**From:** Jeff Tarling  
**To:** Jean Fraser; Jennifer Thompson  
**Date:** 4/17/2014 3:06 PM  
**Subject:** Re: UPDATE: urgent - final Plat 118 Congress for PB signing 4.22.2014

This revised plat was submitted this AM as final (first attachment).

Jen and Jeff- I have told them that we need the info that Jeff has requested (from long ago; in approval letter and recently) that supports the street tree locations before we can sign off on the plat. Re the plat I wonder if we could live with them adding the following note instead:

**118 STREET PARKING**

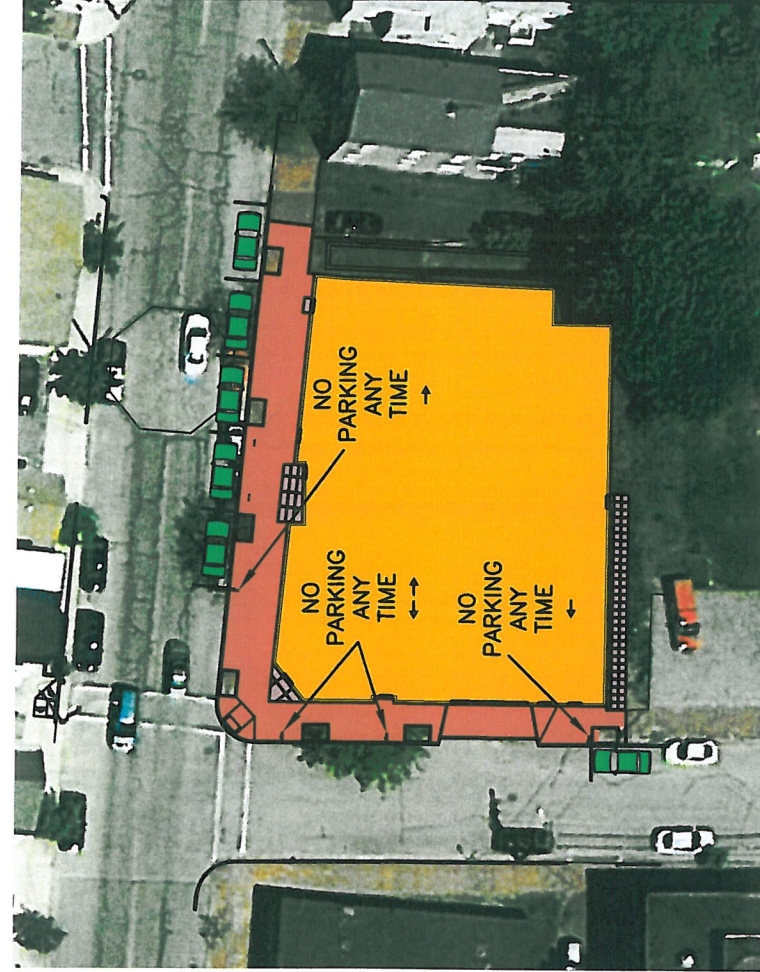
This revision plat shows the tree well modifications noted in the field on Wednesday April 16th. Our goal was to reduce on-street parking tree obstructions.

**"The location of street trees are approximate and final locations will be subject to documented agreement with City Arborist prior to the issuance of a building permit".**
